From: Simon Davis
Sent: 12 October 2018 12:58
To: Peter Cleveland [REDACTED]
Subject: AW/259/18/PL

Simon J Davis MRTPI | Principal Planning Officer, Planning Department, Directorate of Place, Arun District Council |
Location: Planning, First Floor, Arun Civic Centre, Maltravers Road, Littlehampton, BN17 5LF
Internal: 37874 | External: +44 (0) 1903 737874 | E-mail: simon.davis@arun.gov.uk

Block Plan 1 : 500

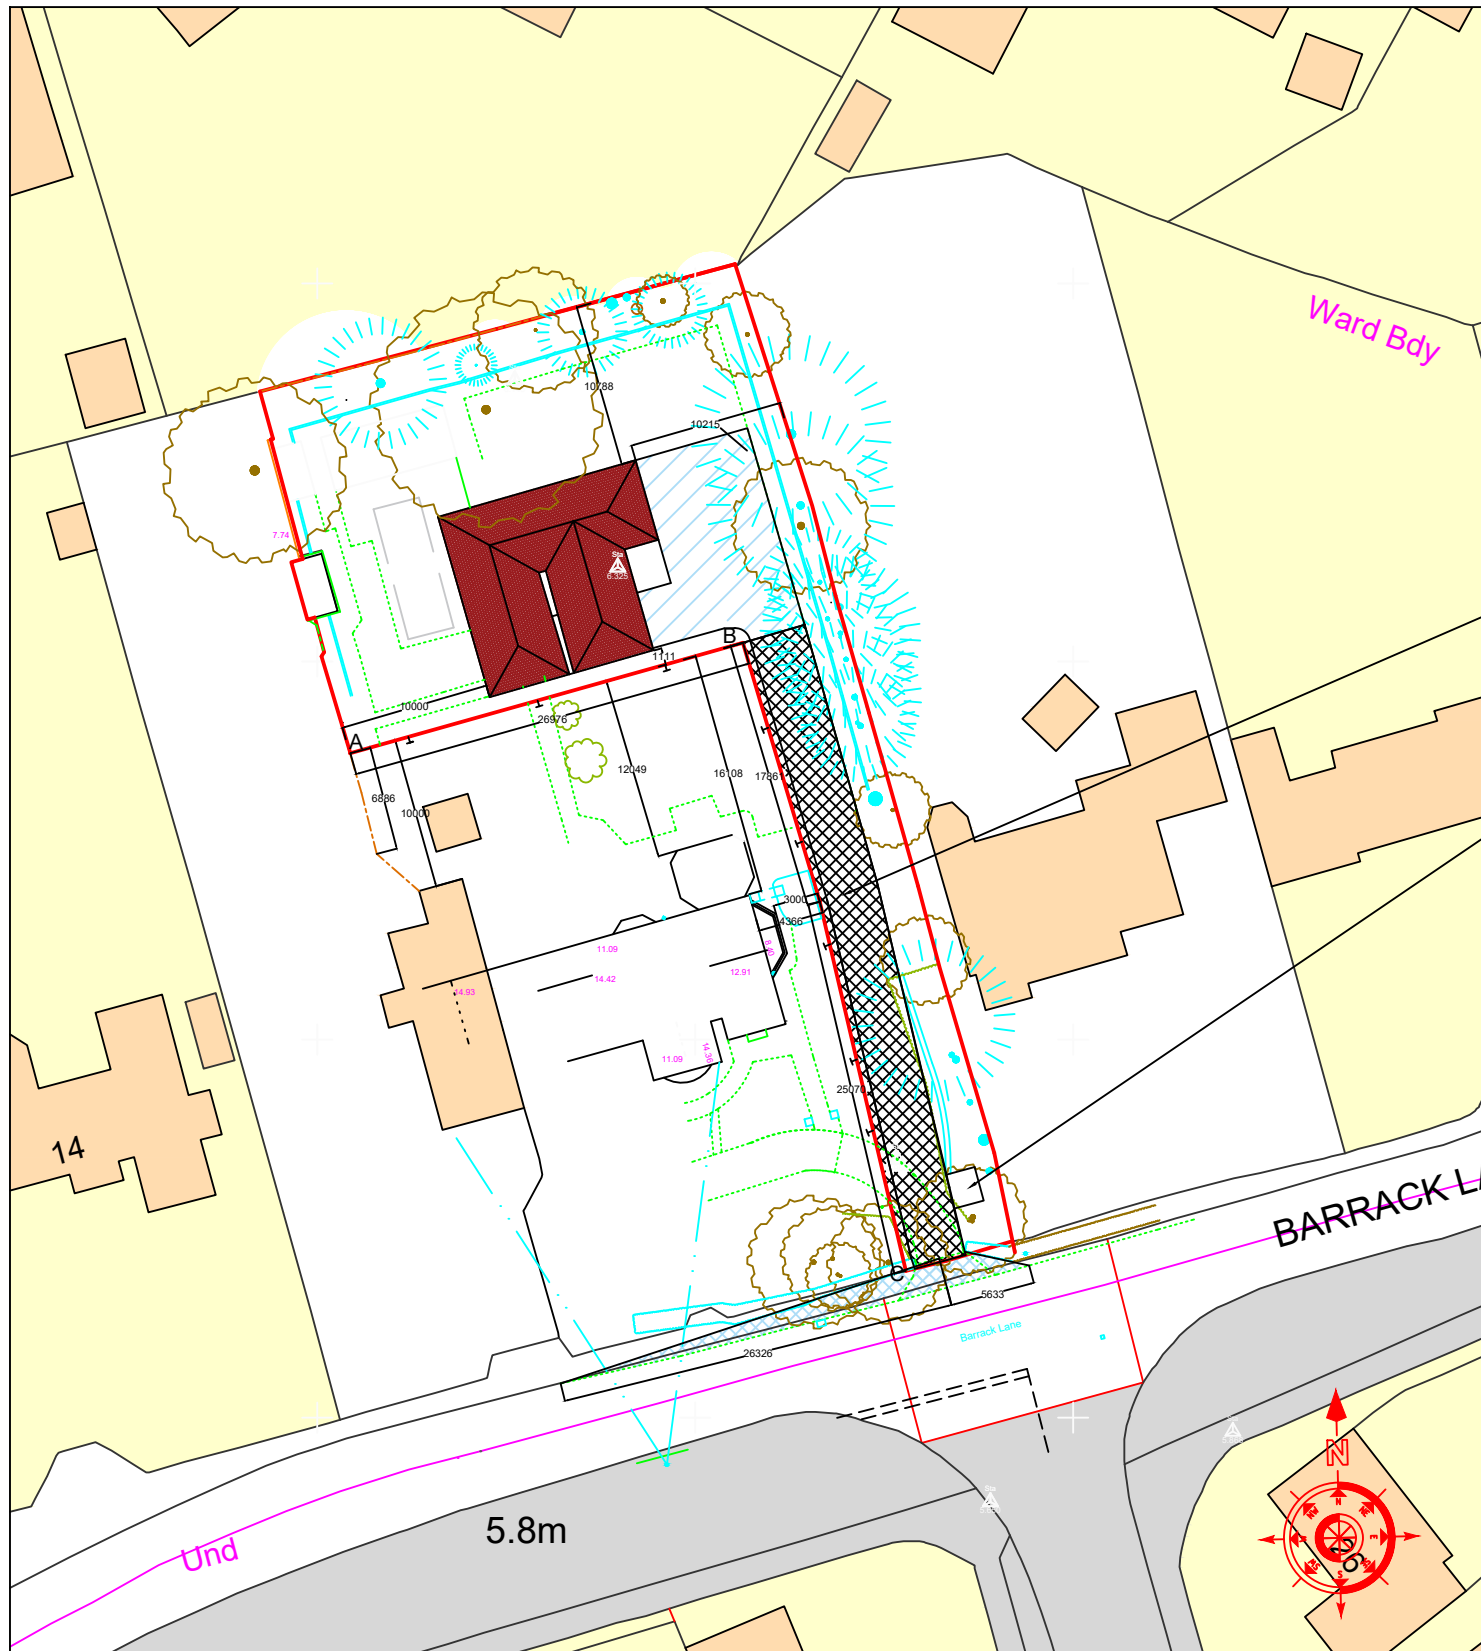
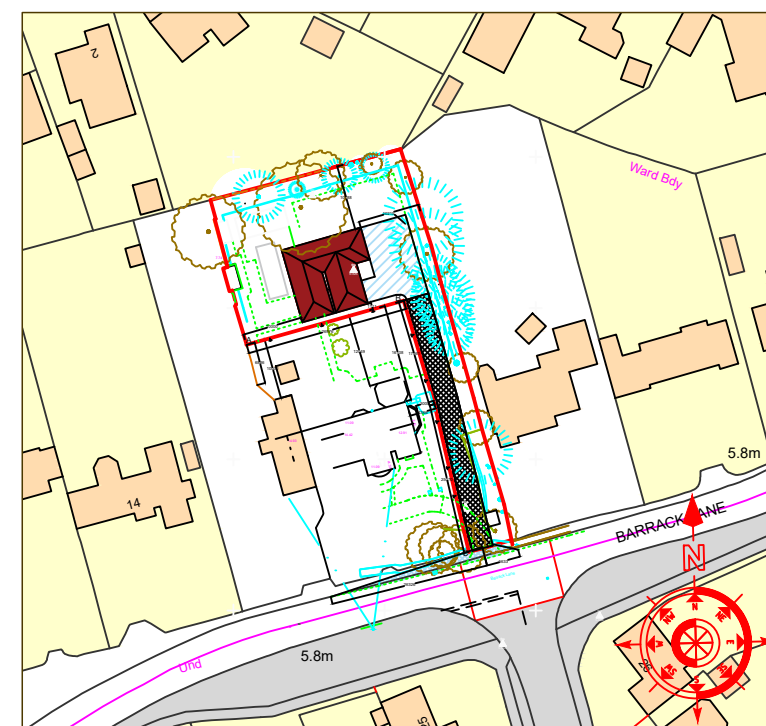
None of your plans have come our correctly in respect of the extent of the existing no. 10 (as I assume there is no proposal to demolish part of no. 10). See attached one of your plans that I have red ringed to show the issue.
